203 Fore Street Meeting - 11/15/17

My wife and I just attended a neighborhood meeting regarding the above property put on by Chatham Lodging Trust. I wanted to share with you two concerns that dominated about 95% of the discussion:

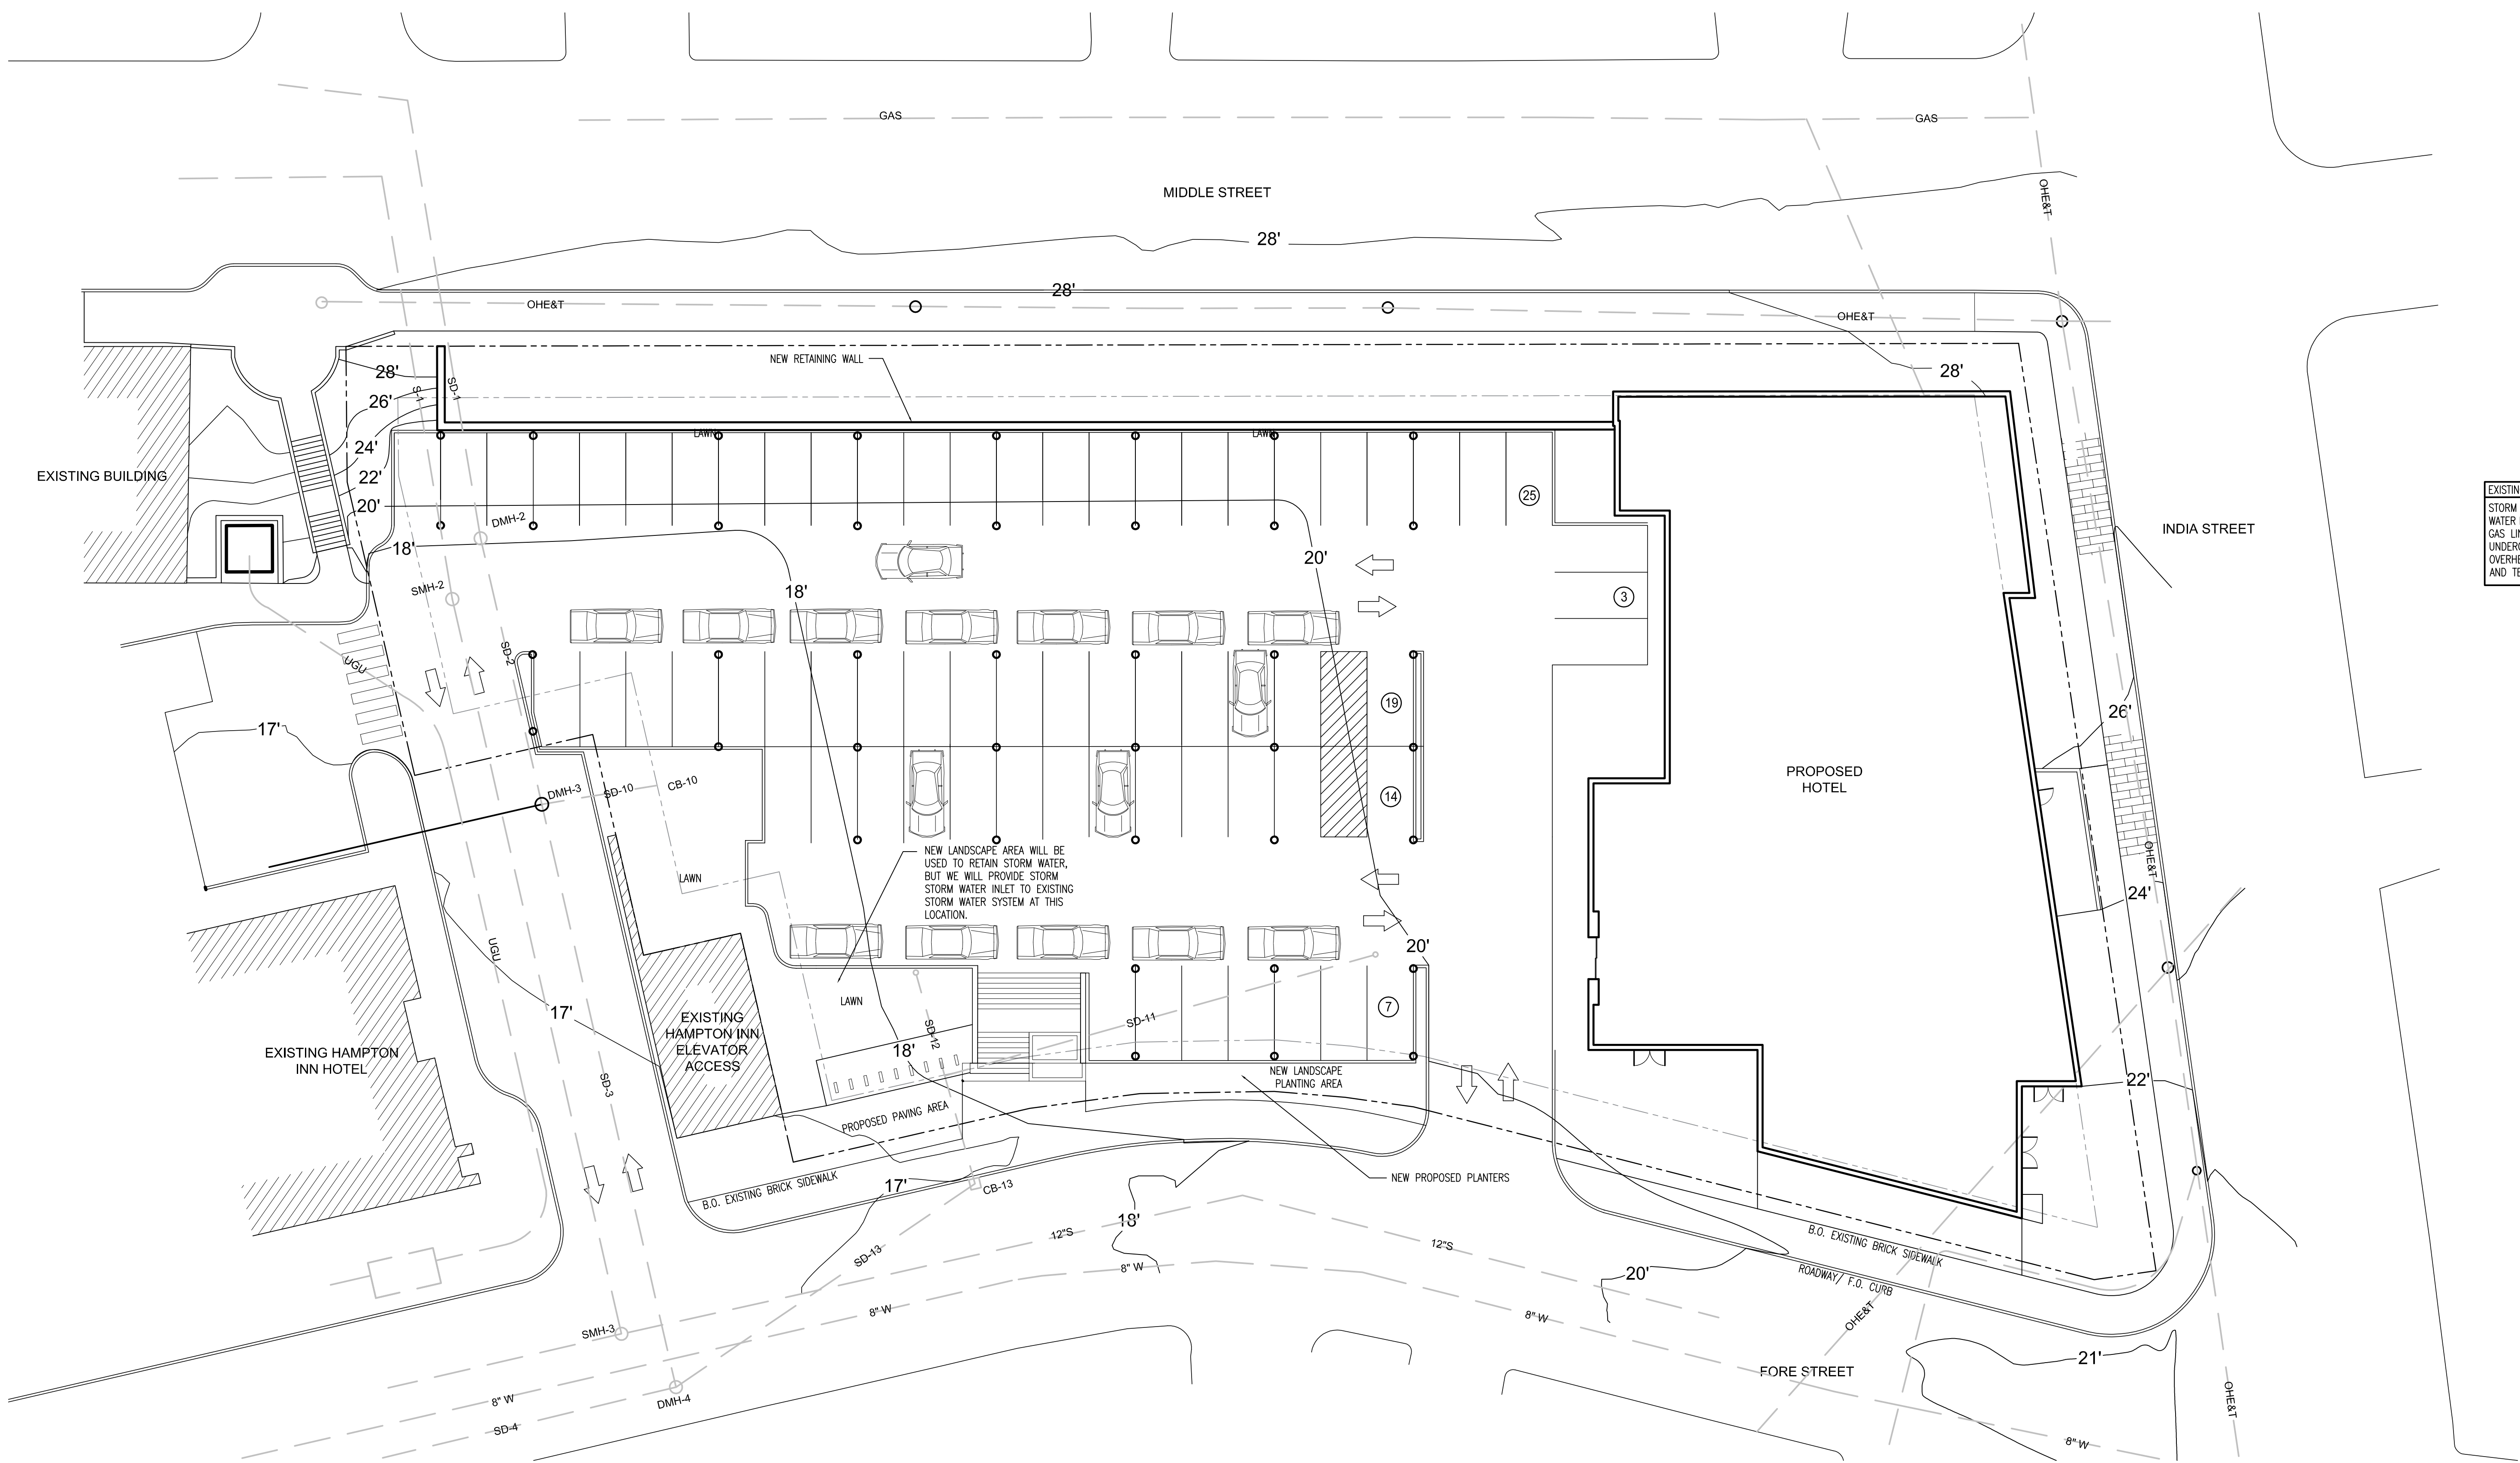
- 1) Green space - The proposed hotel design has minimal landscaping / green space in the current plan. While we were assured that the design complies with the "code", the overwhelming consensus was that more must be done on site to add more landscaping (not hardscaping) and benches on the India Street side of the proposed building and on the corner of India and Fore Streets (see existing plantings for reference).
